CITY OF ALBUQUERQUE

January 17, 2023

**RE: SAMS Academy
6441 Ventana Rd. N.W.
30-day Temporary C.O. - Accepted
Engineer's Certification Date: 12/08/22
Engineer's Stamp Date: 06/10/21
Hydrology File: A10D010**

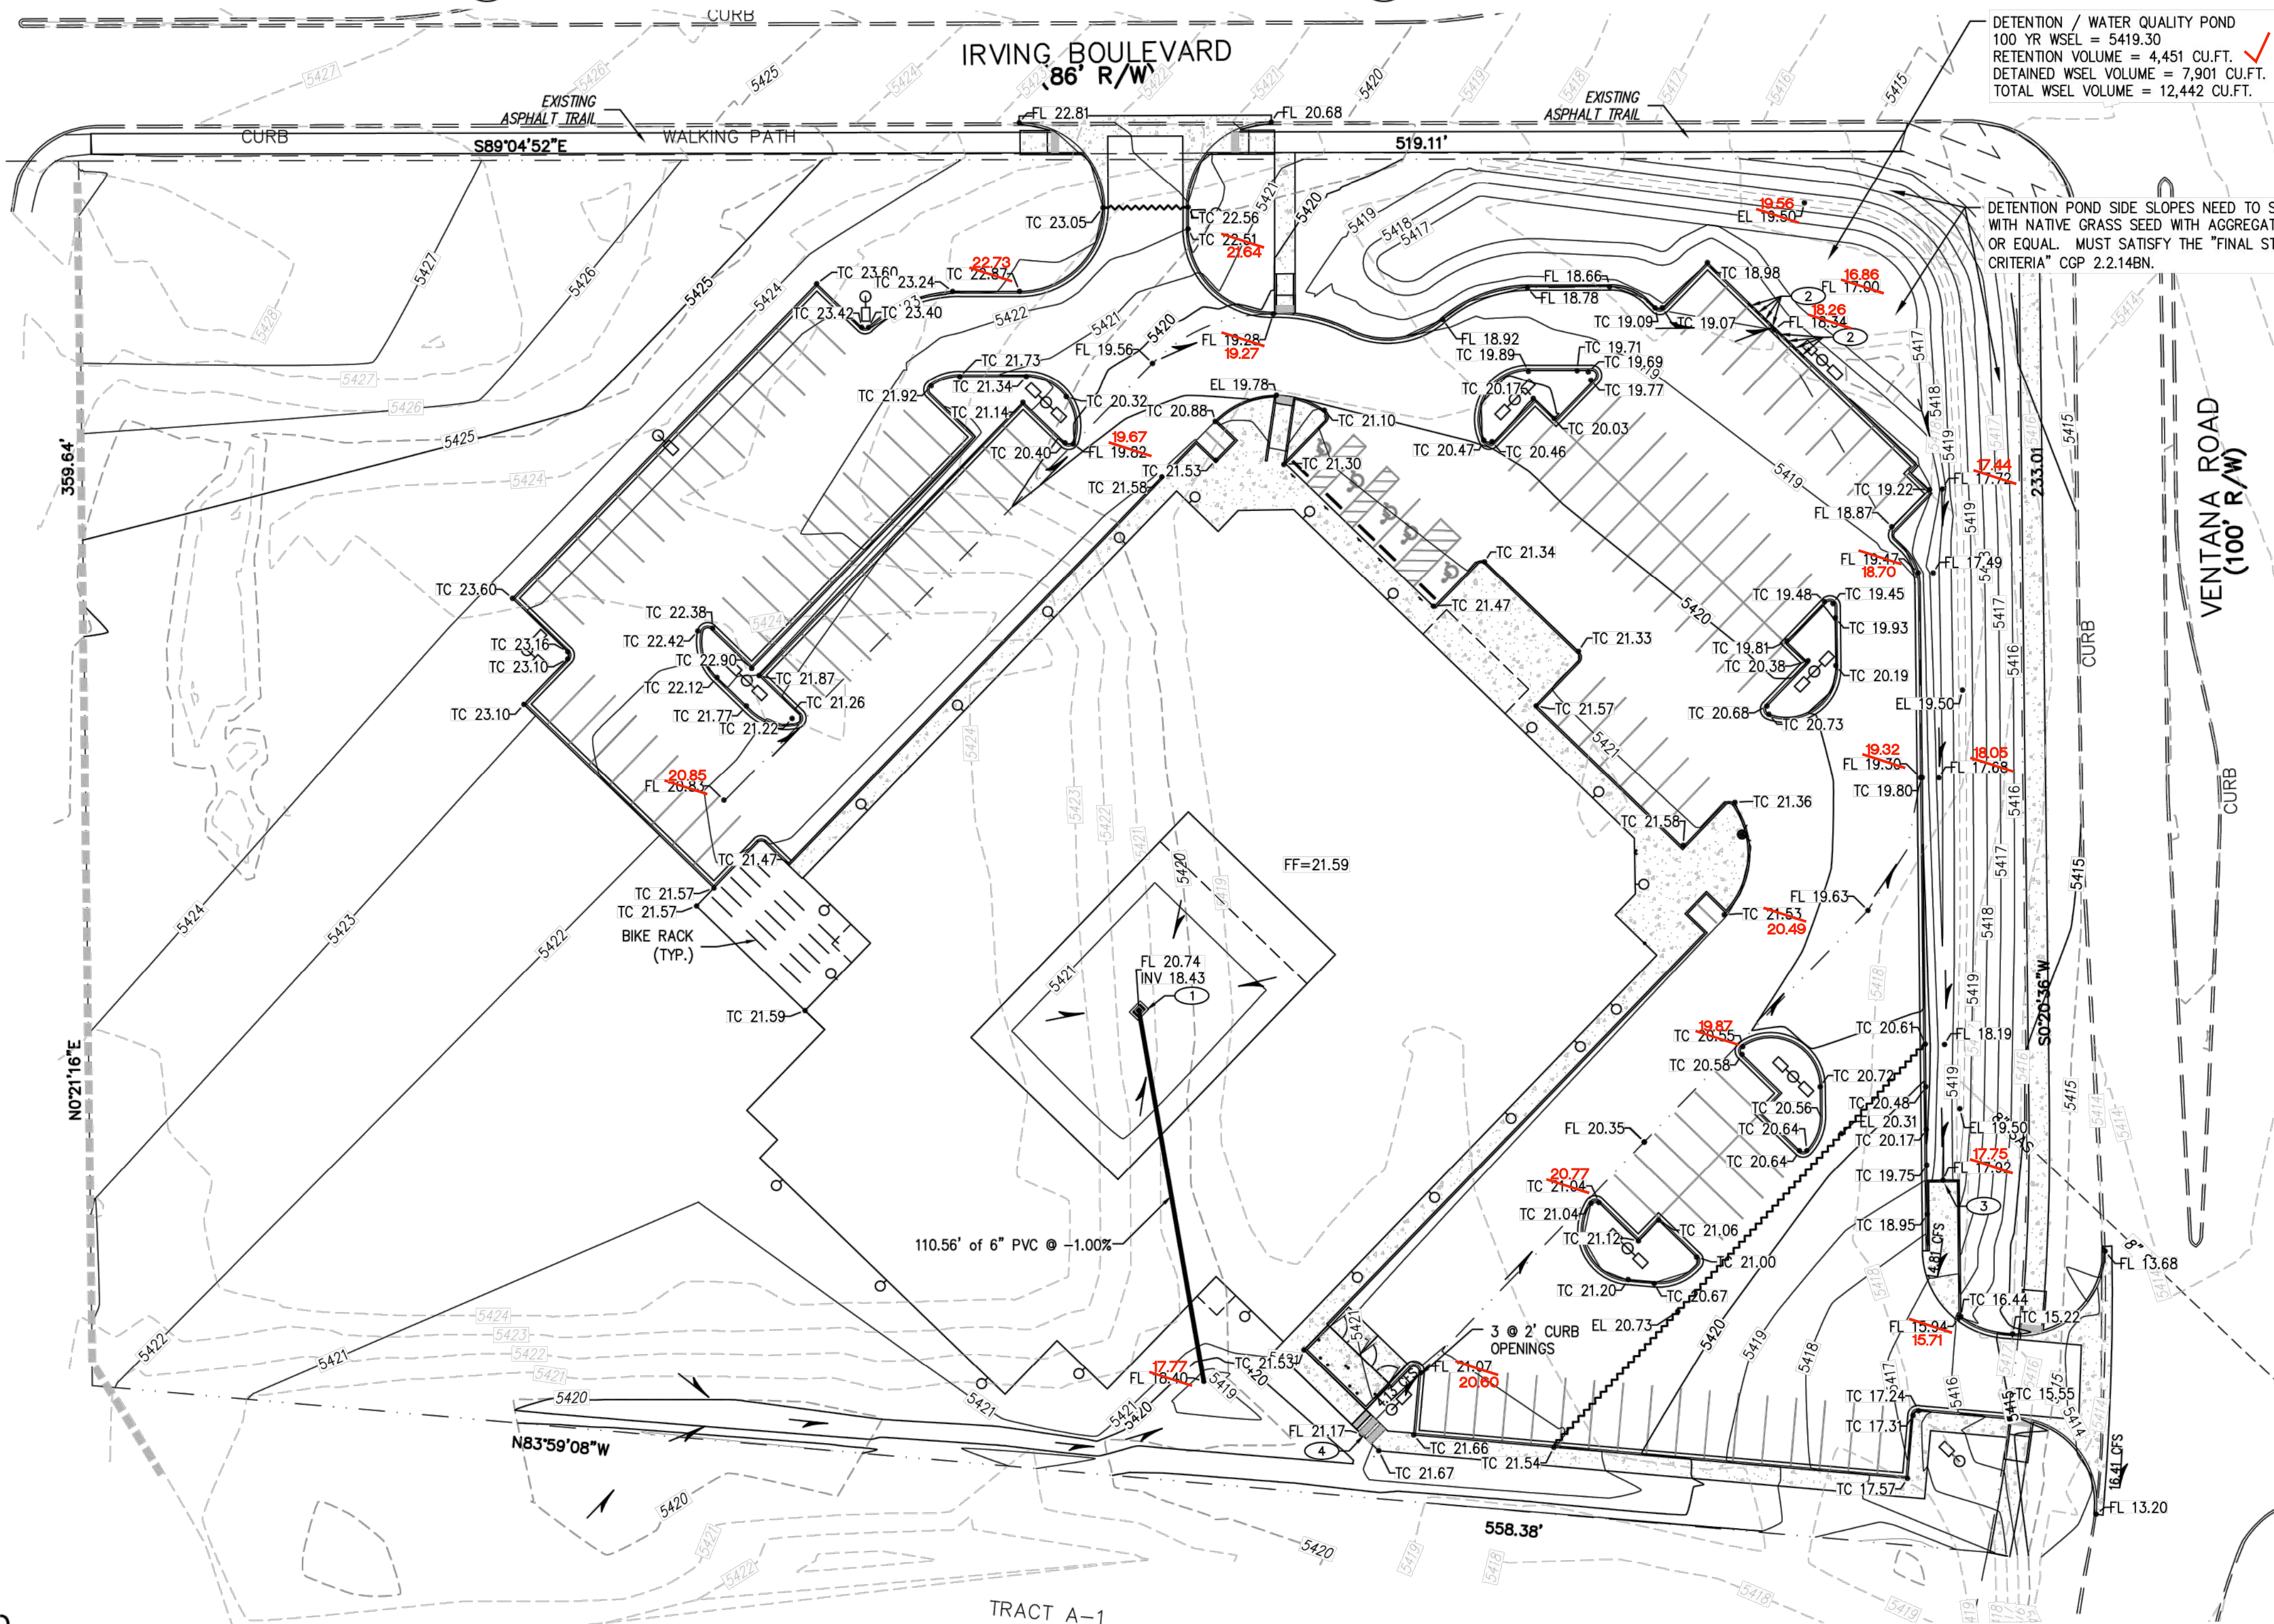
1. Please submit photos that these tow deficiencies are done.

a. Please install the steel plates on the sidewalk culvert installed by the dumpster.

b. Please explode the storm pipe from the interior court yard in stormwater quality pond.
